Our ref: HMS ID 13183

Advice on Response to Submission – State Significant Development

Proposal: WSU Indigenous Centre of Excellence

Major Project reference: SSD-64916225

Z:\jobs\23234338\civil\sheets\01\234338-TTW-01-DR-CI-01011.dwg

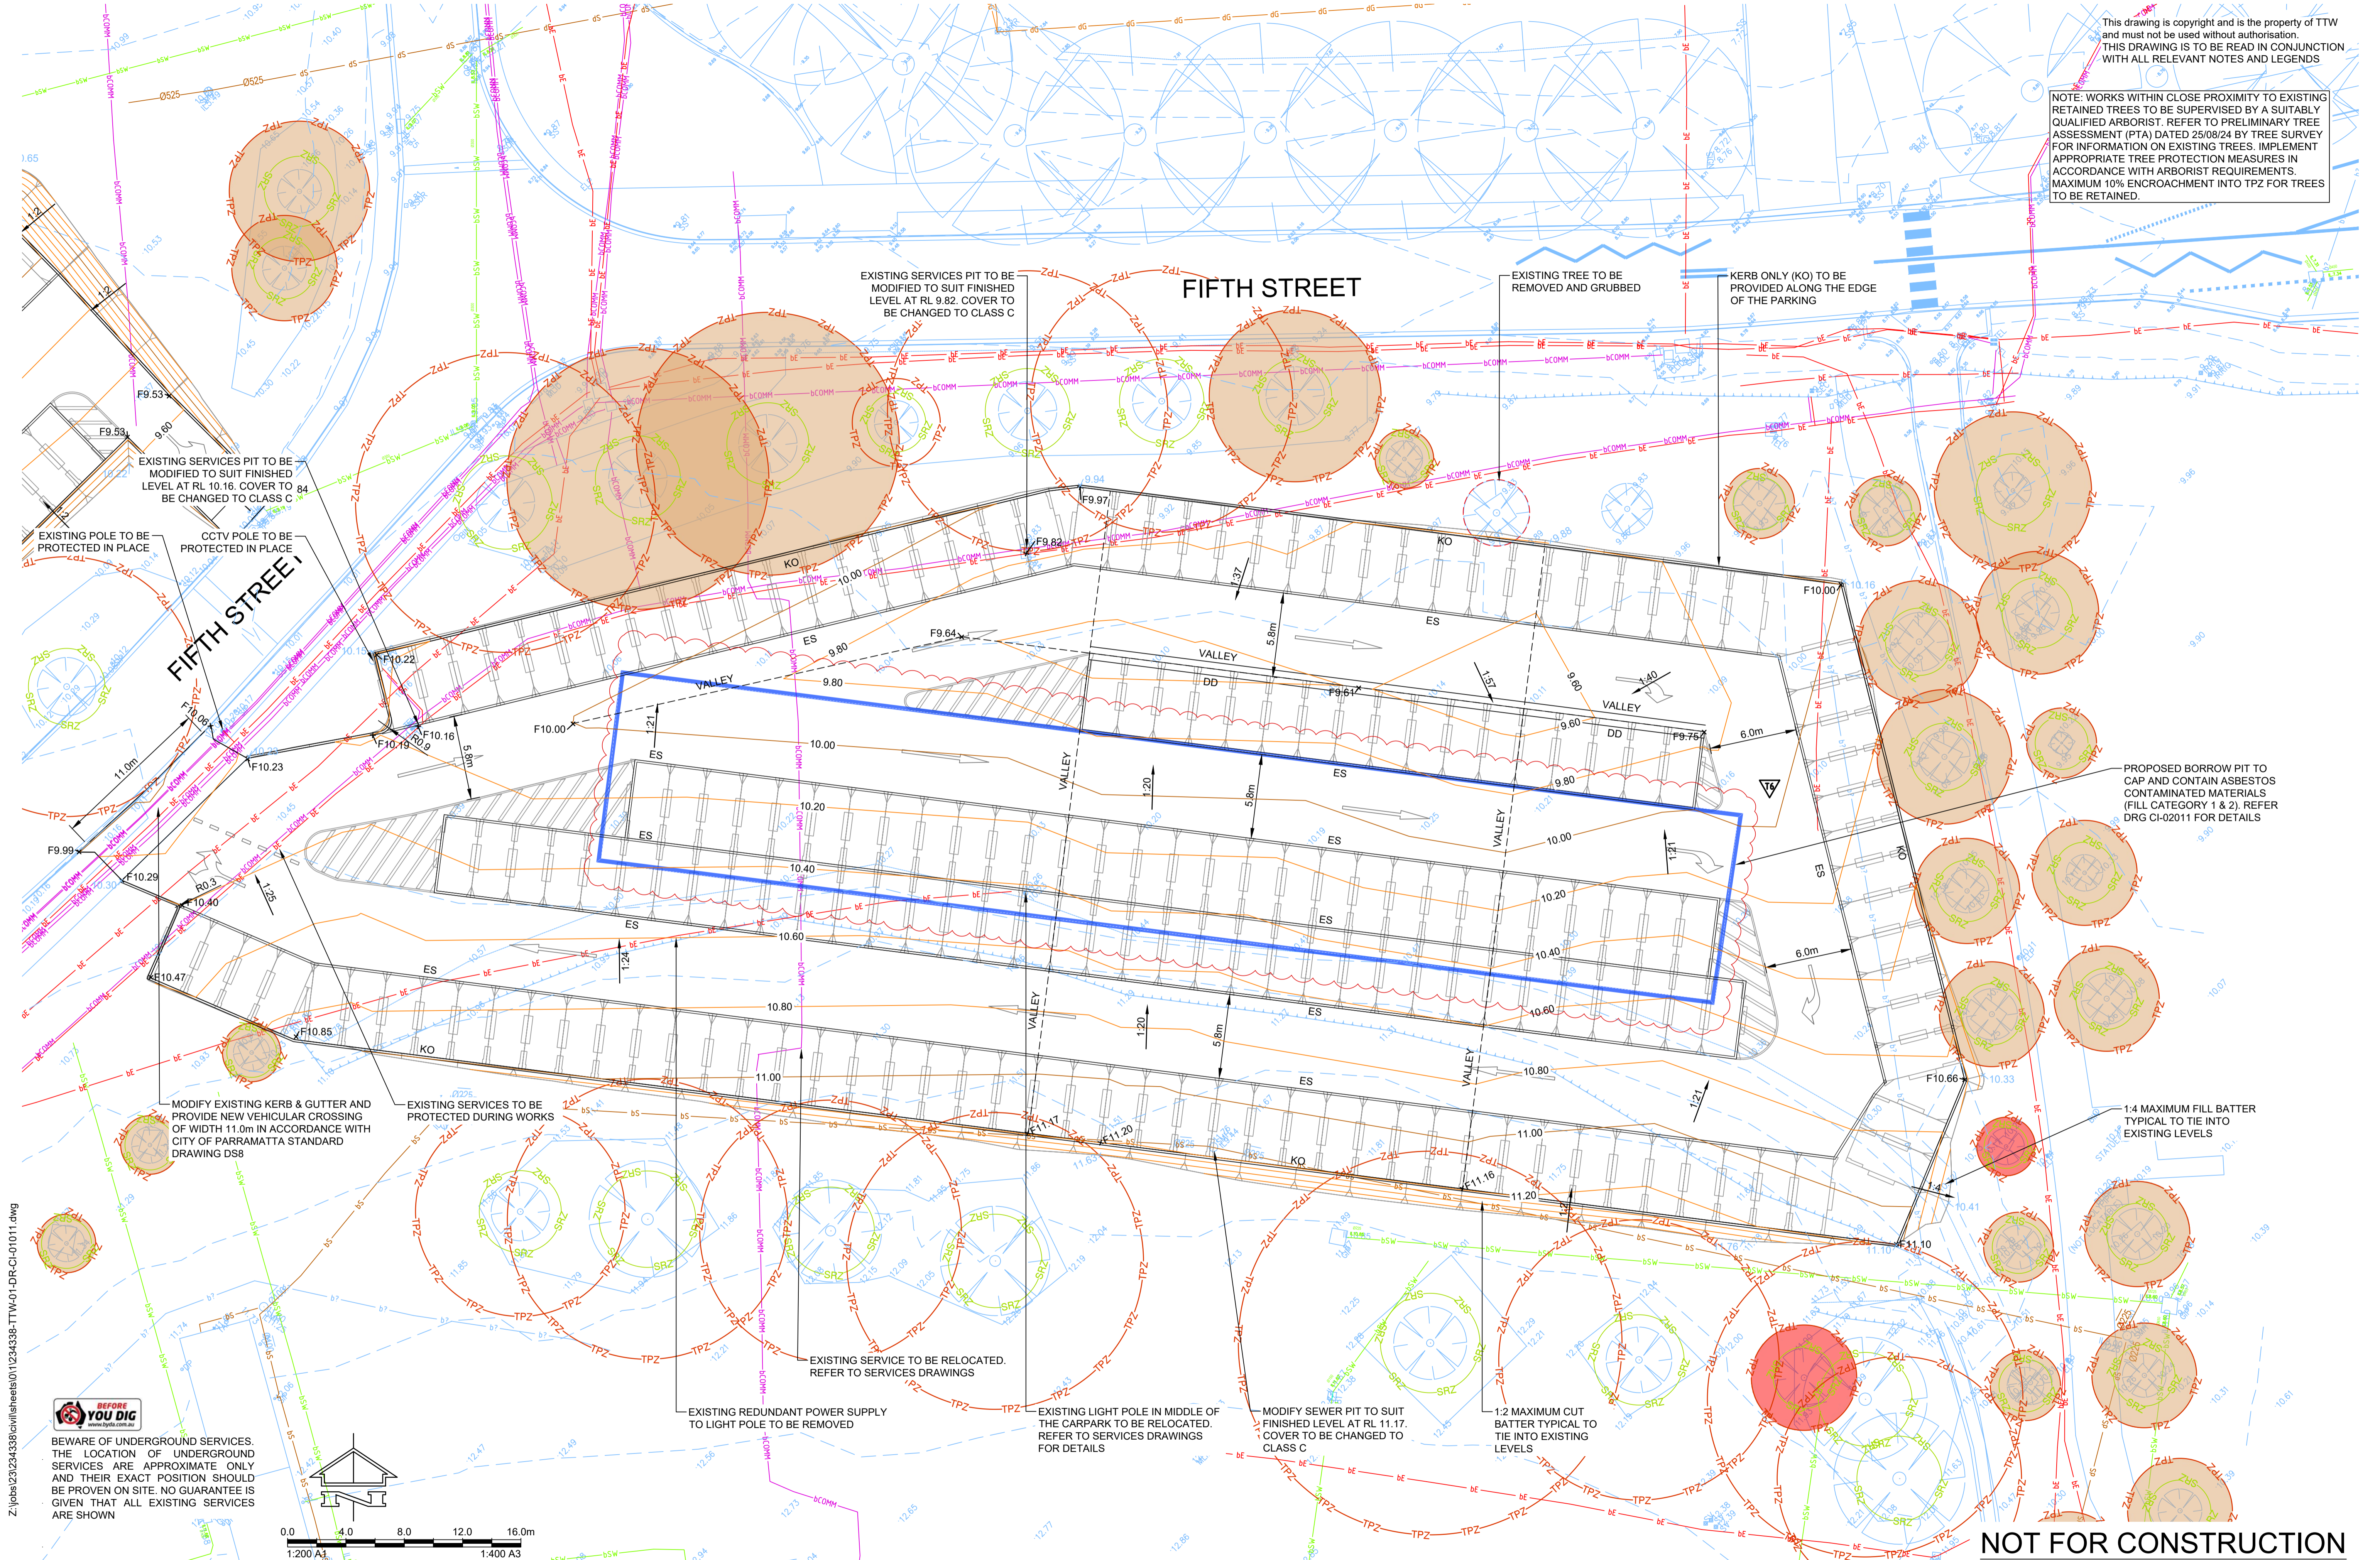
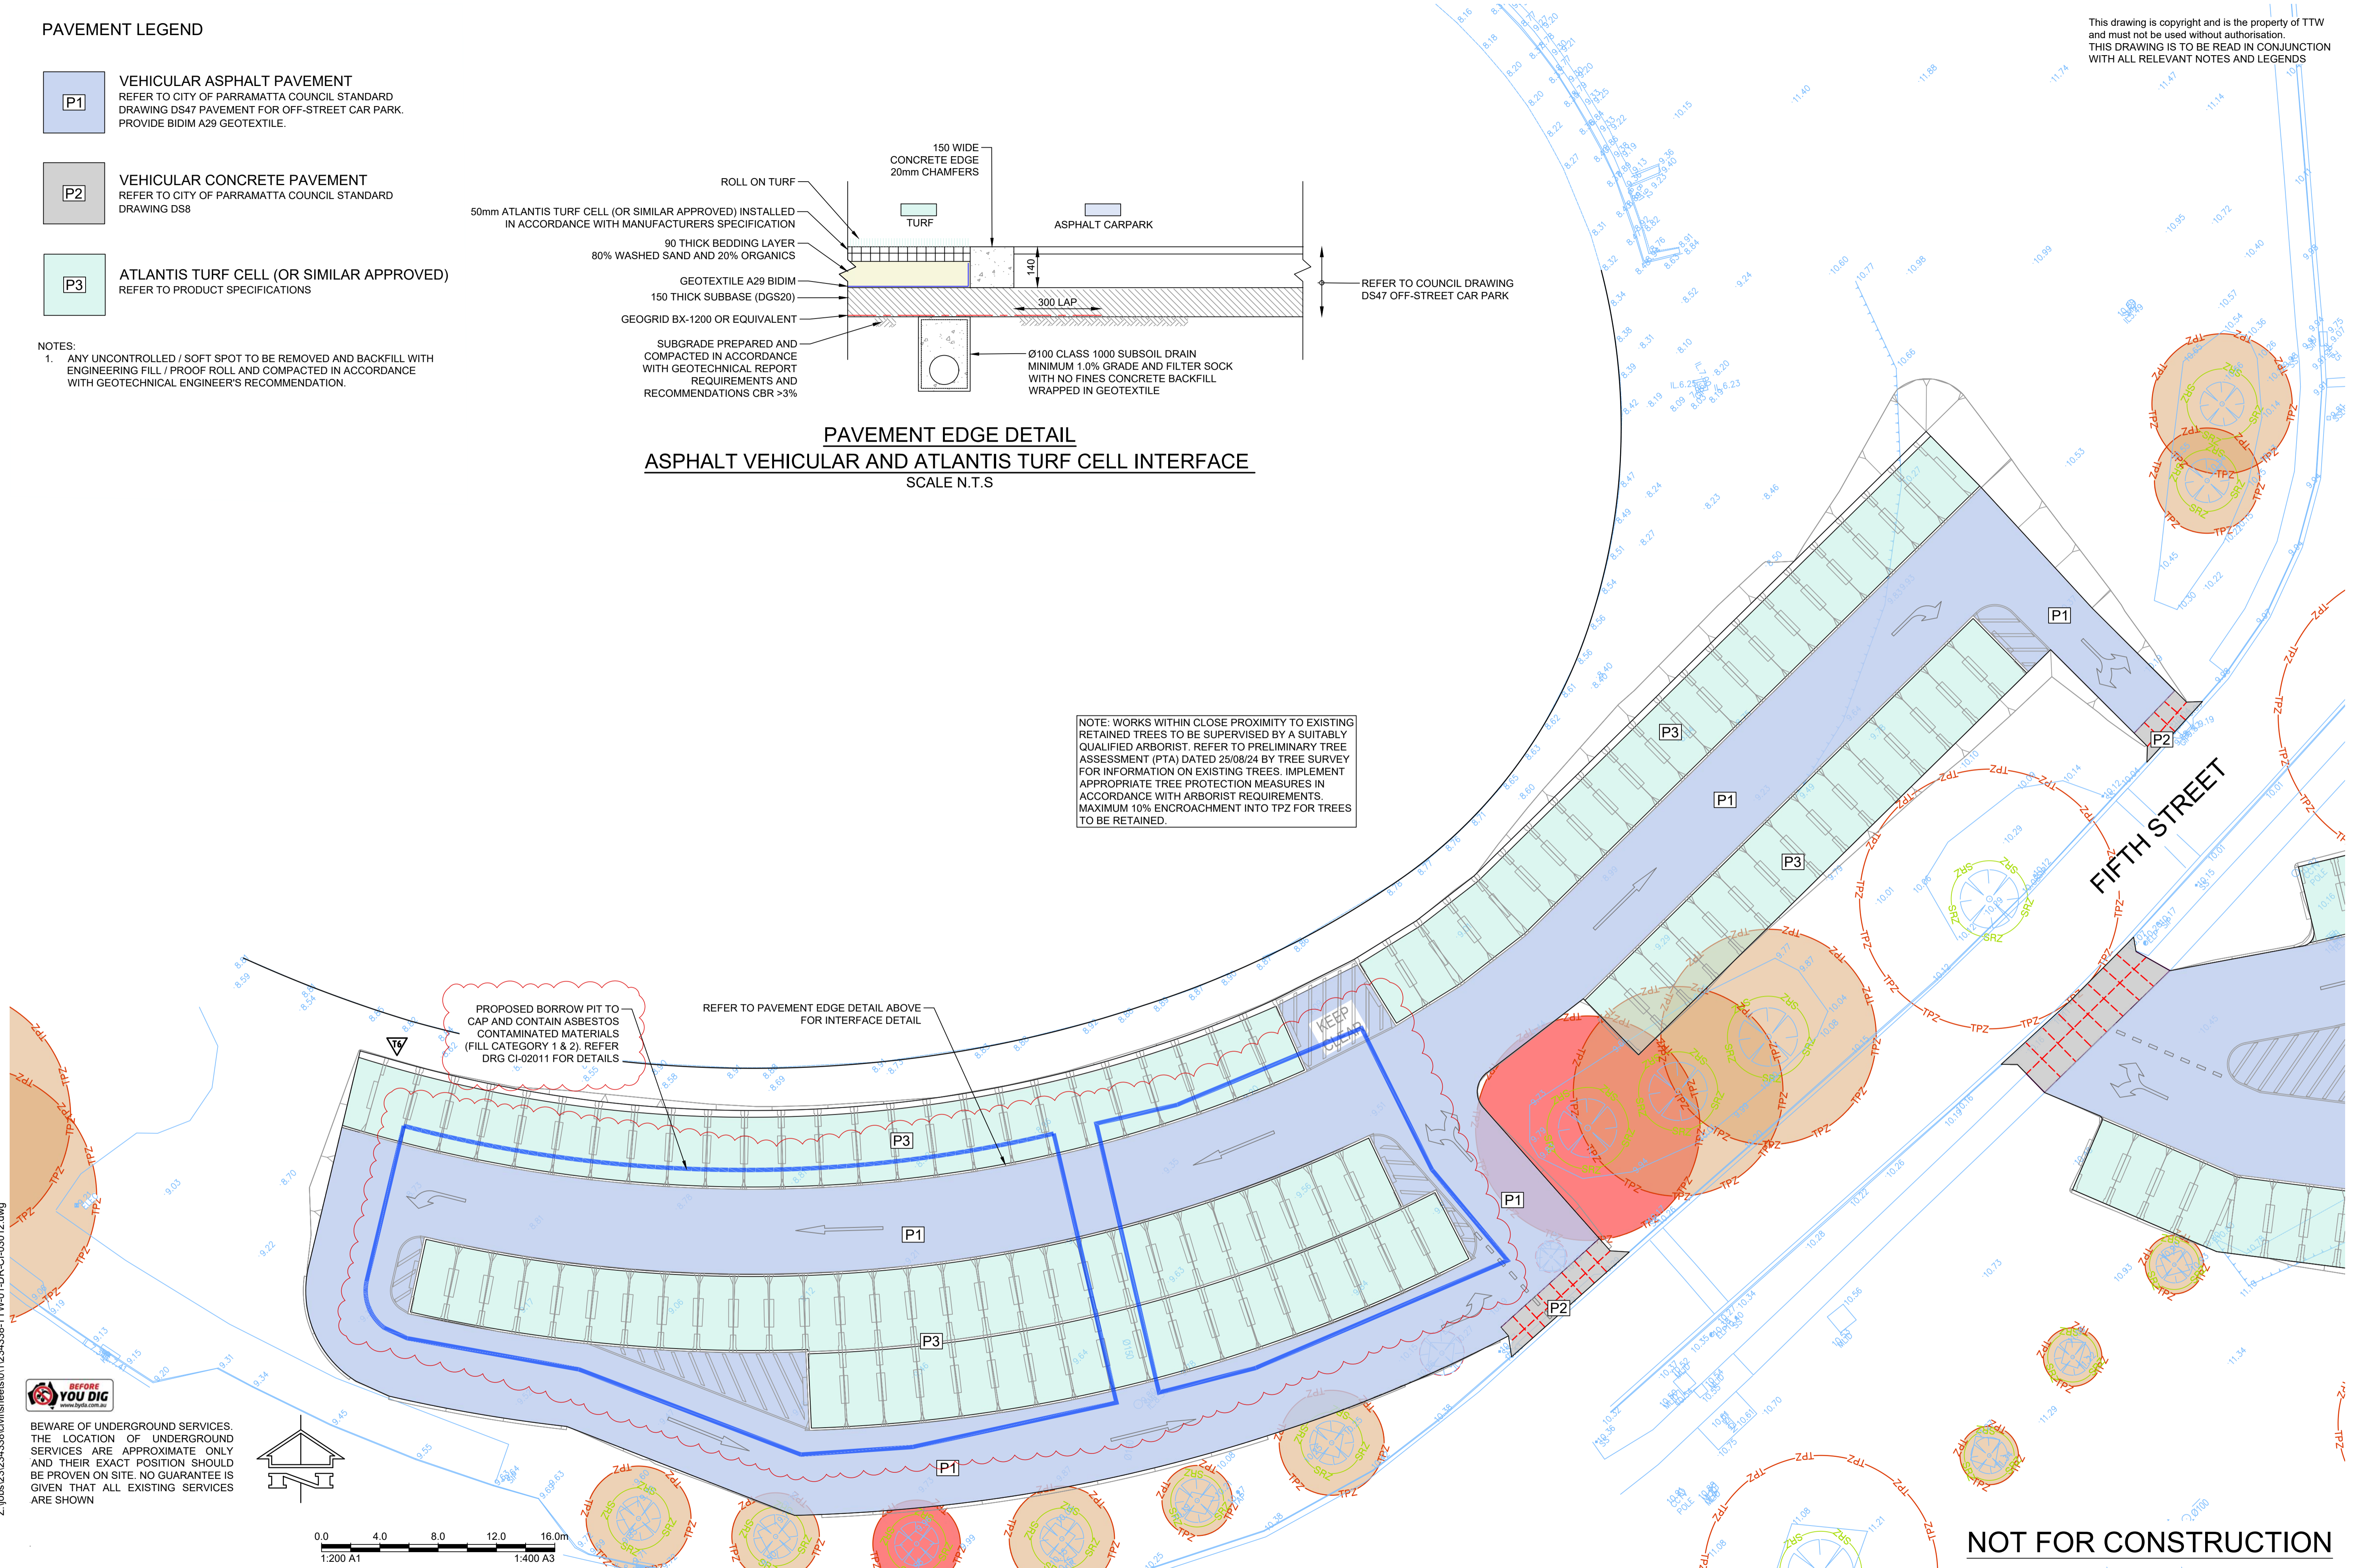
- Our key concern continues to be the infringement of the eastern carpark into the highly significant landscape adjacent to Building ED as defined by the line of the former Ha Ha. As per our previous advice, development in this area would be contrary to the policies of the conservation management plan (CMP).

- We note that the borrow pit in the eastern carpark has been relocated away from the location of the Ha Ha as per our previous advice (HMS ID: 11828), but the design of the eastern and western carparks are otherwise unchanged.

- No justification has been provided for why the re-design of the eastern carpark has not been considered.

- If archaeological resources associated with the former Ha Ha walls are identified during works, it is recommended that the nature and extent of excavation for the temporary car park is reconsidered to avoid impacts to this feature.
